## **MEMORANDUM**

**June 30, 2021**

**SUBJECT: Review of Ellicott Sand and Gravel LLC Mine Permit Application**

Illustration of General Direction of Alluvial Ground Water Flow Direction

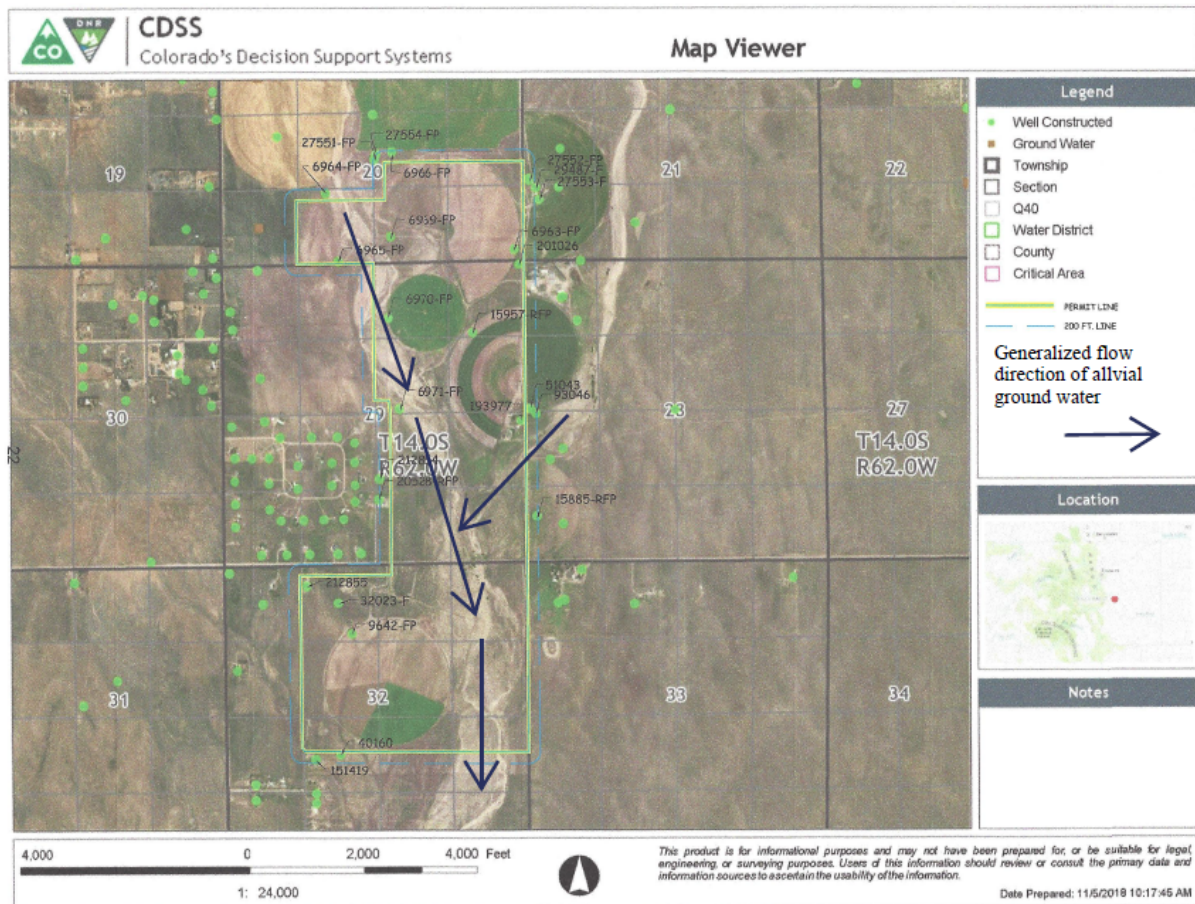
1. The application material still does not include adequate information or data regarding the occurrence of groundwater in the alluvial aquifer that is also the source of the material to be mined. Intercepting groundwater in UBS alluvial aquifer during mining would require a well permit and replacement plan. The application material indicates that the economic sand resource is 70 feet thick and that depth to groundwater exceeds 70 feet across the area to be mined. The applicant further states that the conclusion that depth to water is greater than 70 feet is based on a review of 24 wells. The names and locations for these 24 wells are provided in a table in Exhibit II in the August 28, 2020 letter. The table does not include depth to water data. In addition, only six of the 24 wells are screened in the UBS alluvial aquifer. The remaining 18 wells are bedrock wells and are not appropriate for determining depth to water in the overlying alluvial aquifer. The only depth to water data provided are static water levels measured in three domestic wells installed in the early 1970s: permit nos. 6969-F, 6971-FP and 9642-FP. The depth to groundwater in these wells, at the time of construction, is less than 50 feet which contradicts the conclusion the depth to water is greater than 70 ft across the site. The applicant states that mining will not occur below 10 feet above the water table in the UBS alluvial aquifer. It is difficult to see how this can be accomplished if there is no current depth to water data across the area to be mined. A water table map based on current depth to water data should be constructed for the site to determine the depth to the water table across the area to be mined and to determine direction of groundwater flow.
